I am writing regarding a householder planning application reference: **2024/62/93588/W**
Erection of two storey and single storey rear extension at 114 Slaithwaite Road, Meltham,
Holmfirth, HD9 5PW.

Drawing number
01 B.

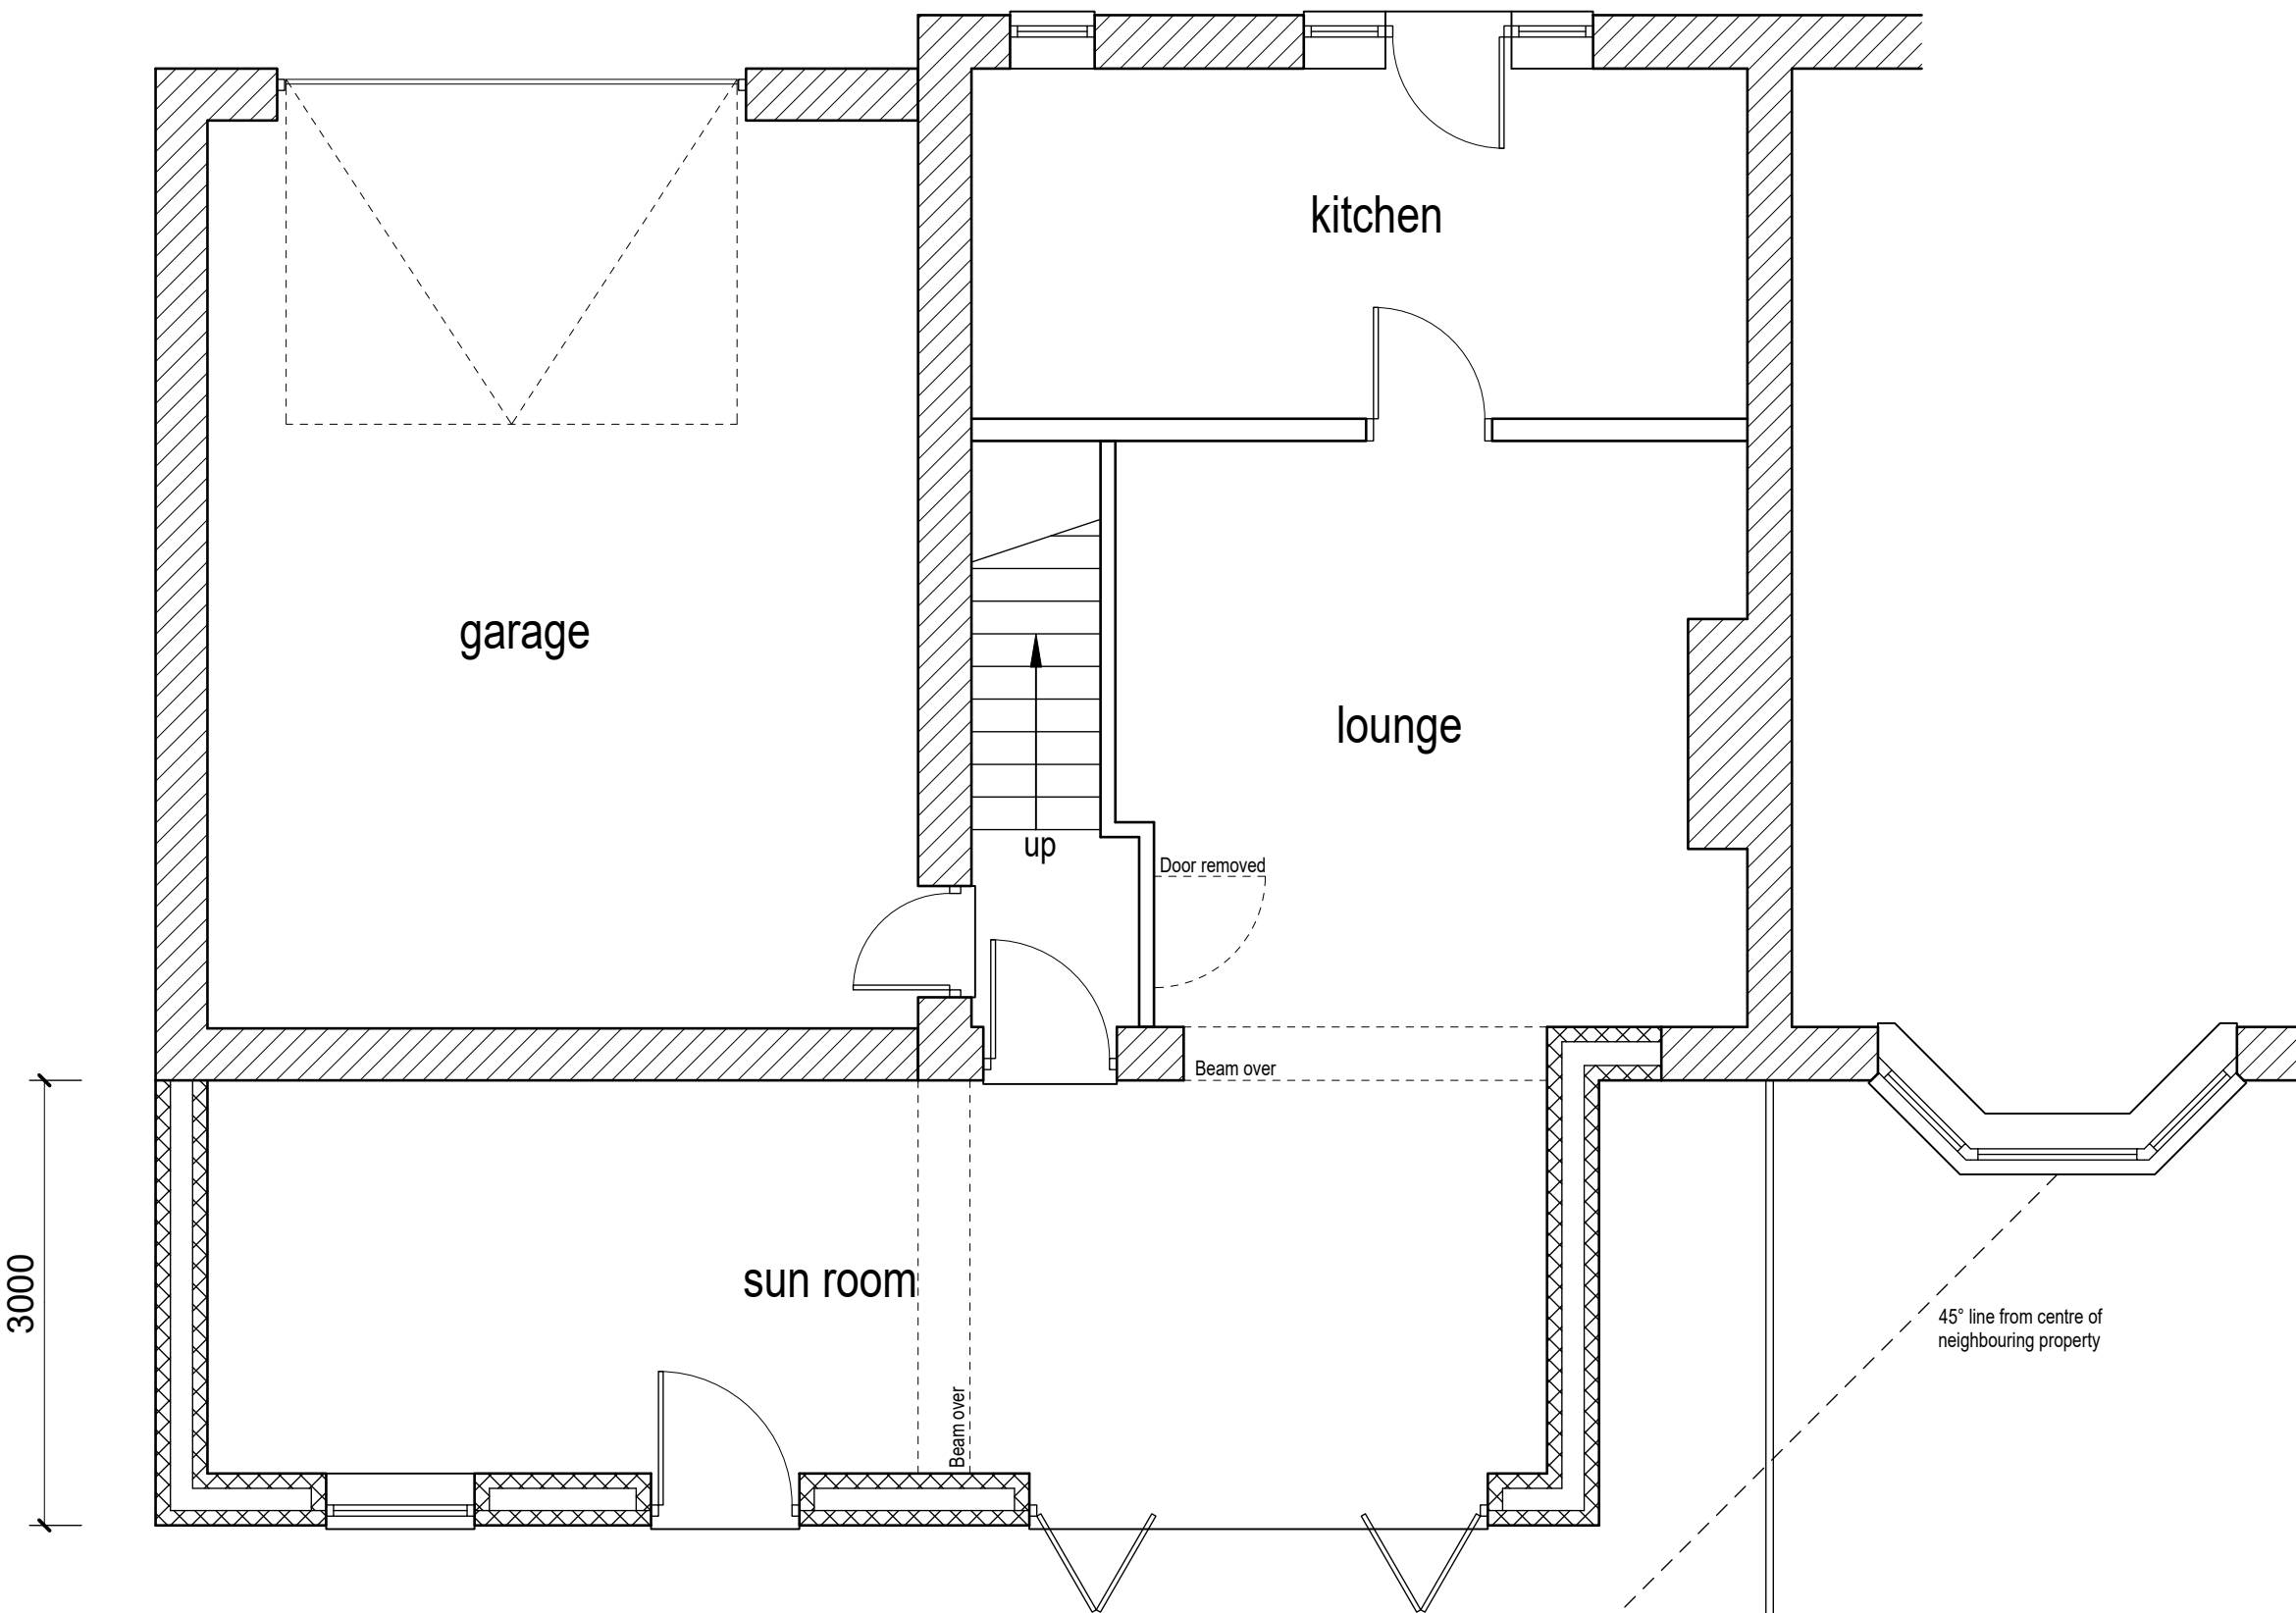
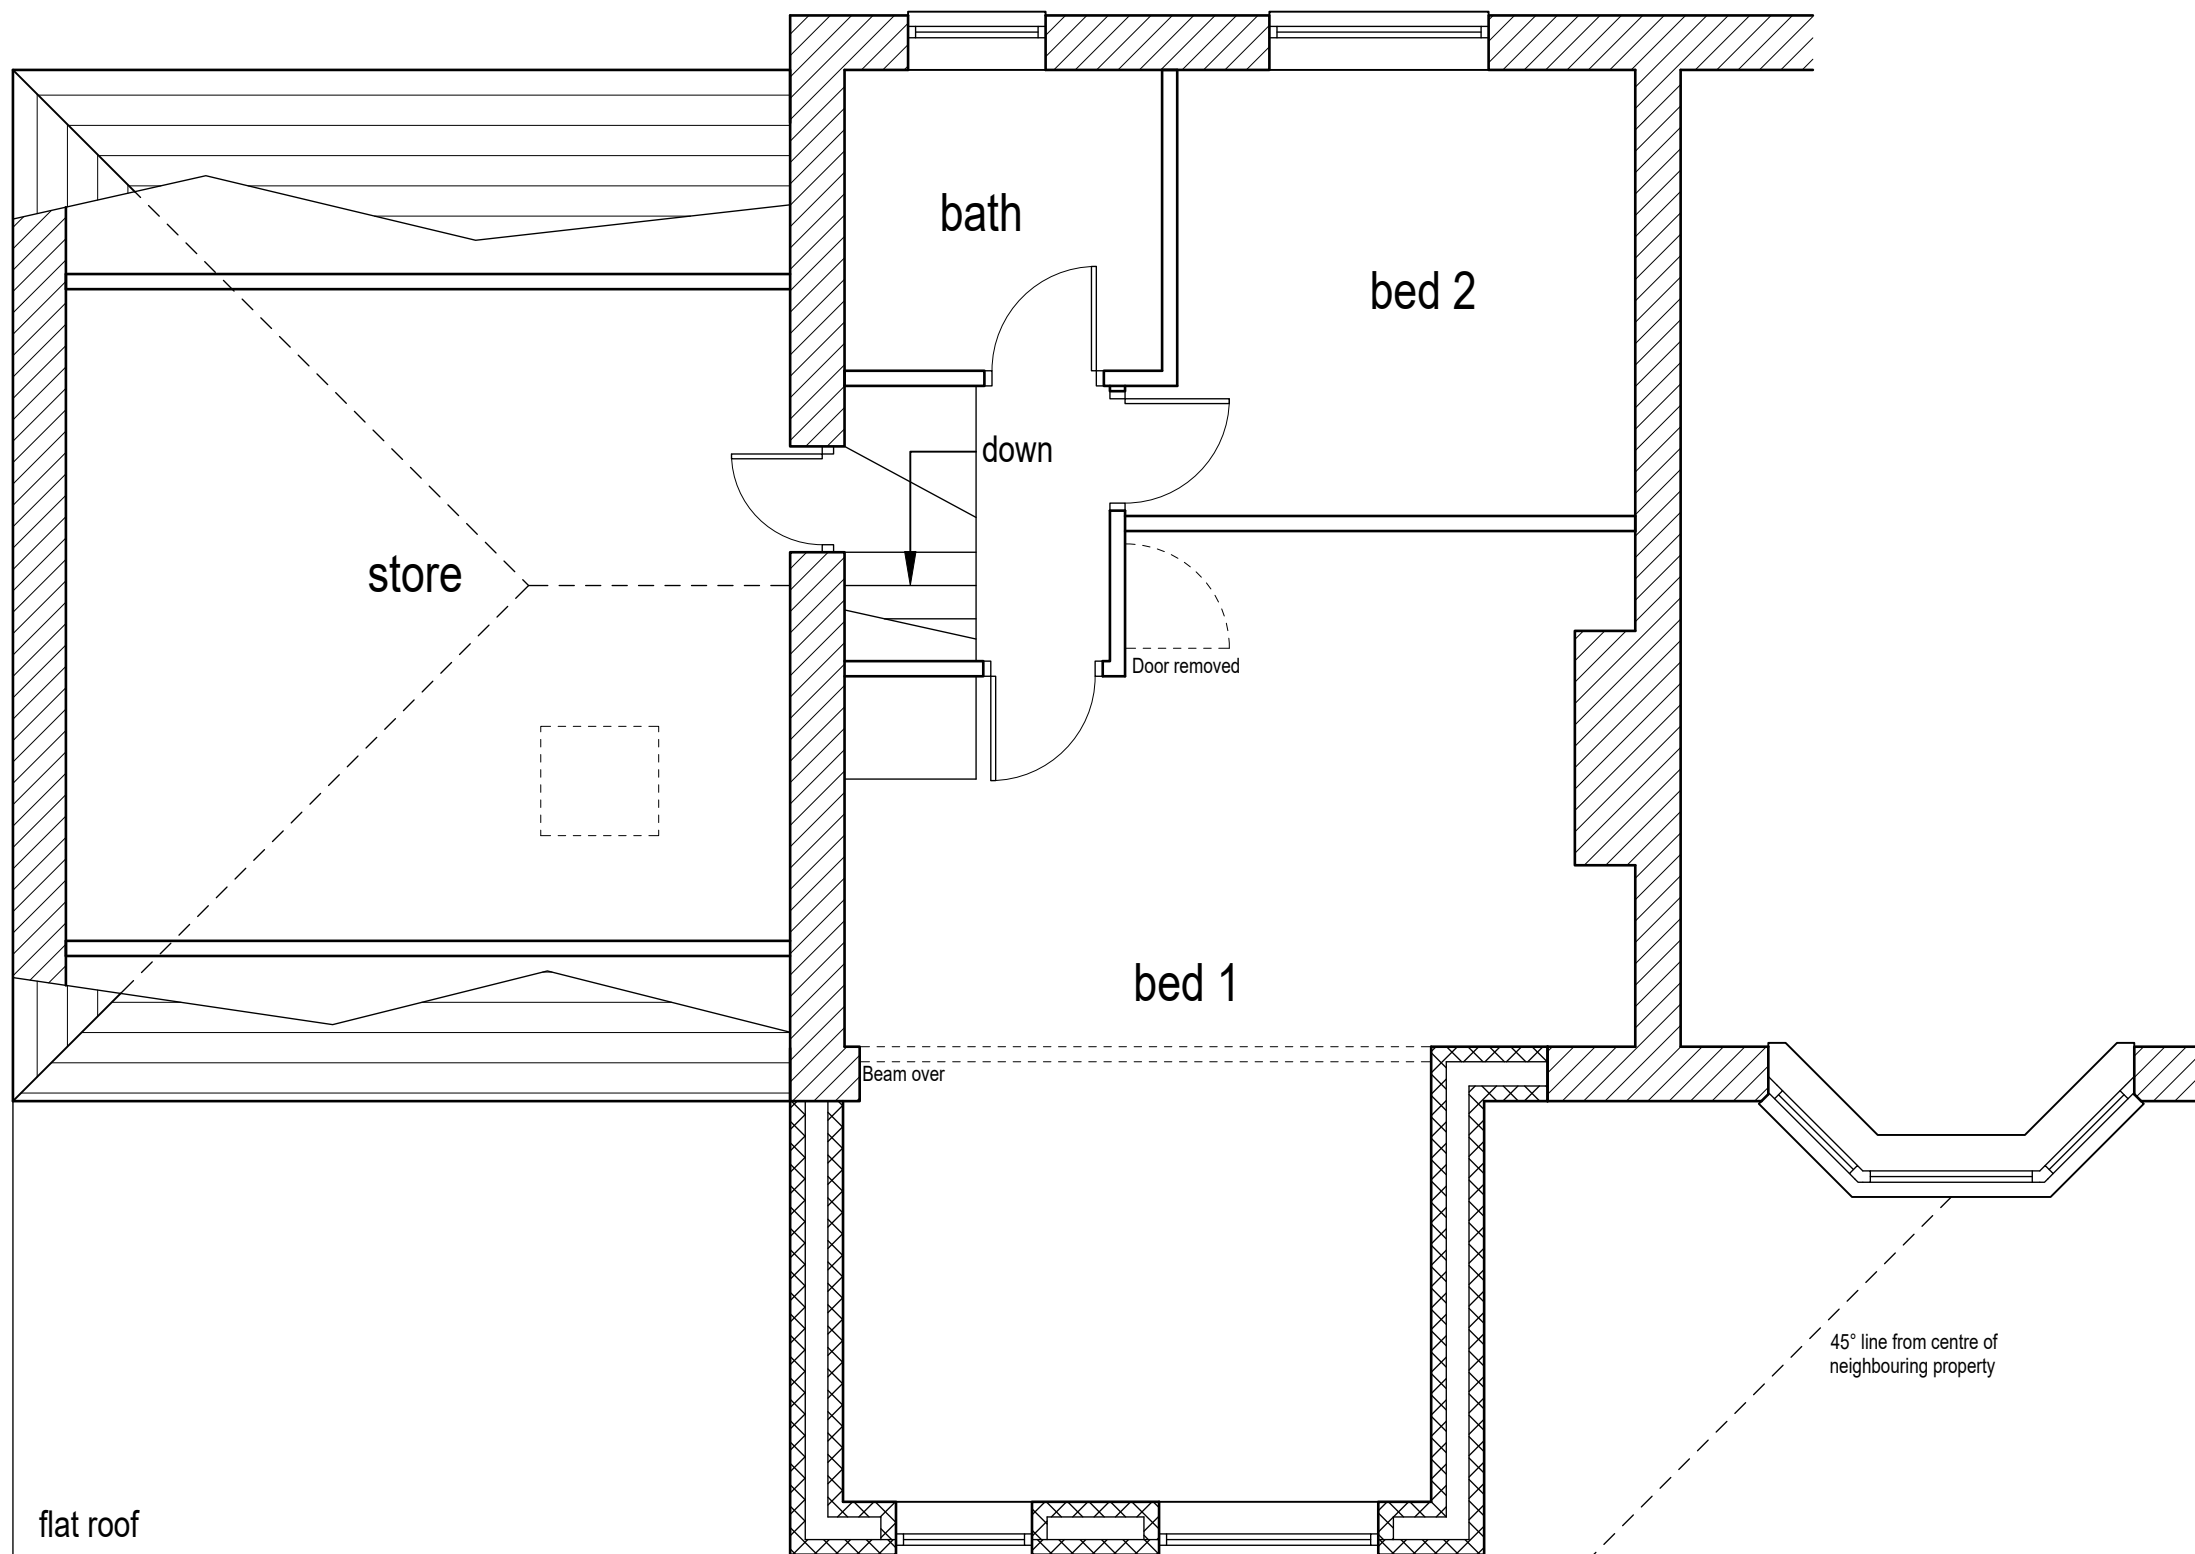
- The submitted drawings don't state how far the extension is set away from the boundary, nor the height of the extensions.
- The 2-storey rear extension is considered overbearing given the distance to my property and most notably adjacent ground and first floor habitable **bay** windows. We feel this will unreasonably overshadow habitable rooms and private garden areas and will materially affect the amount of natural light currently enjoyed by my property.
- Recently updated plans submitted show the 45 degree projection line to the centre of the bay window rather than the edge which again impacts on the natural light of my property.
